**From:** [Rael, Rudy E.](#)  
**To:** ["Scott McGee \(scottmmcgee@gmail.com\)"](#)  
**Cc:** [Abiel X. Carrillo](#)  
**Subject:** ABQ School of Excellence  
**Date:** Tuesday, June 28, 2016 1:47:00 PM  
**Attachments:** [image001.gif](#)

Based upon the information provided in your resubmittal received 6/10/16, the above referenced Grading and Drainage plan cannot be approved for Building Permit until the following comments are addressed:

ALBUQUERQUE SCHOOL OF EXCELLENCE

## GRADING AND DRAINAGE PLAN

Grading and Drainage Plan

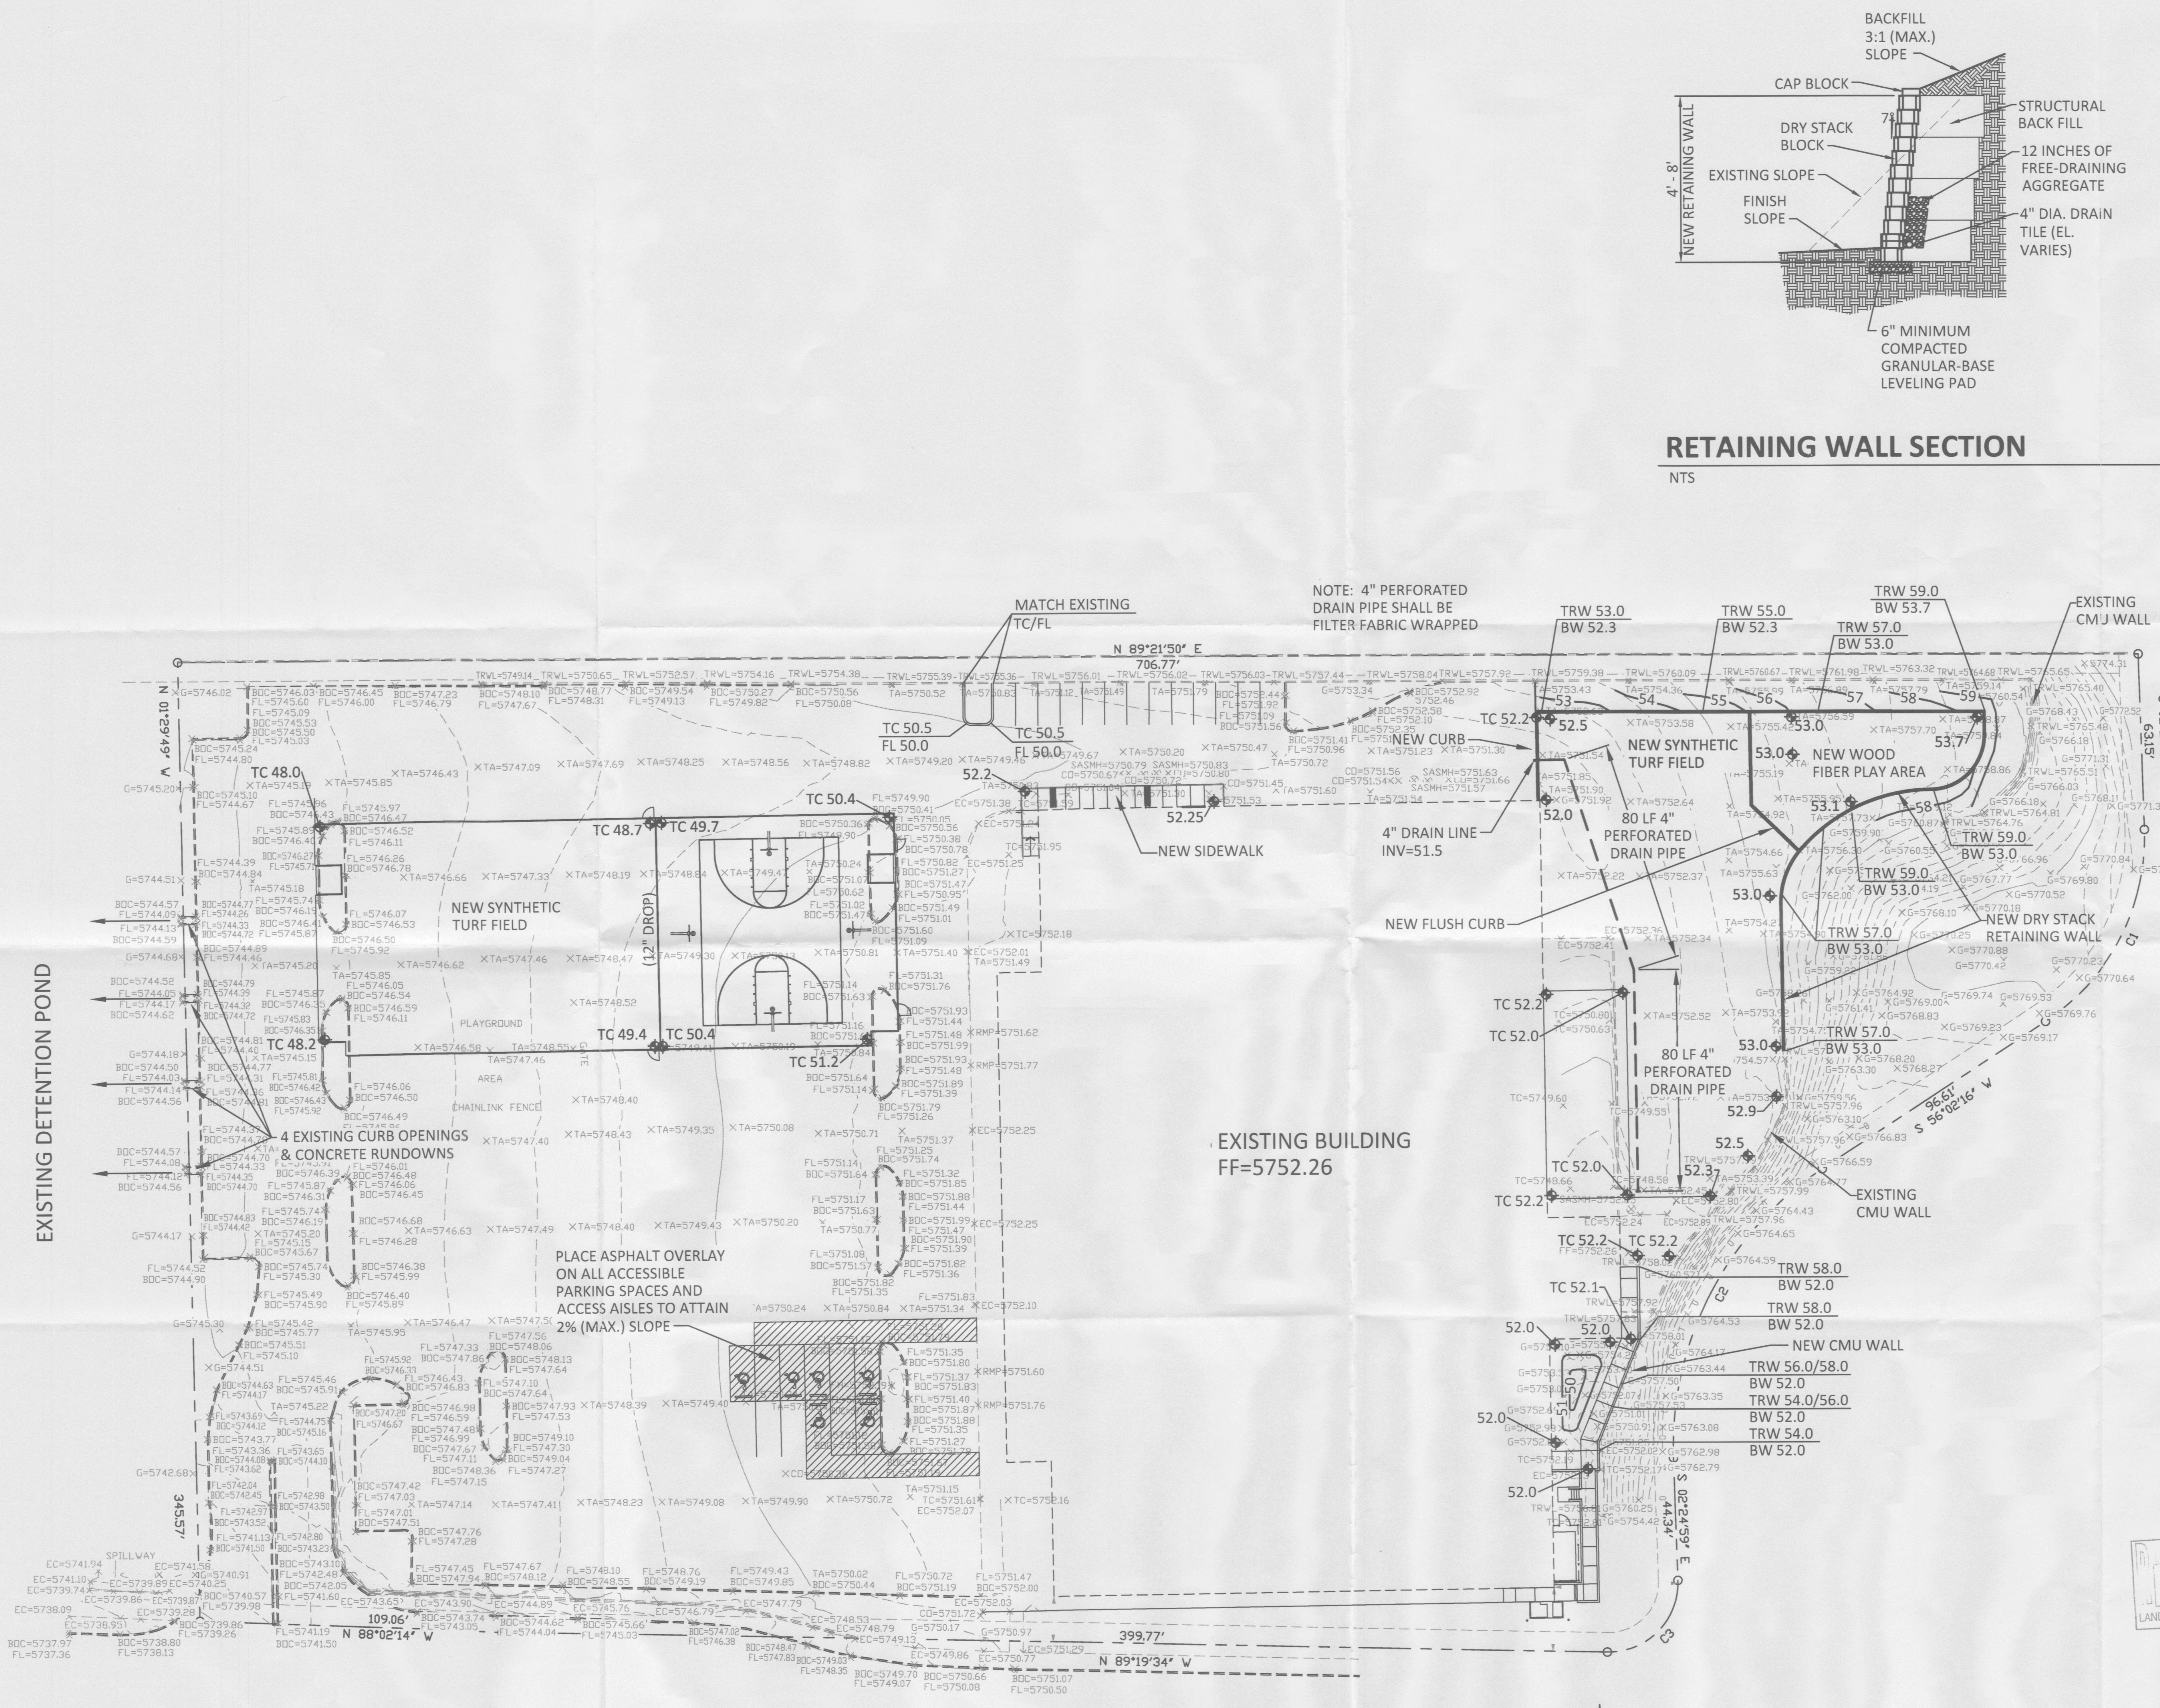
- Provide a detail for the 4" perforated pipe. Show how it will be kept from clogging.
- Show the pond the plan. Provide inlets and outlets.
- If the pond is being used for the First Flush, it must be cleaned, free of weeds and what not.
- Is it possible to provide curb openings in the landscape Islands for first flush ponding?
- Label the double line on the east side of the building. What is it, wall, curb, etc.?
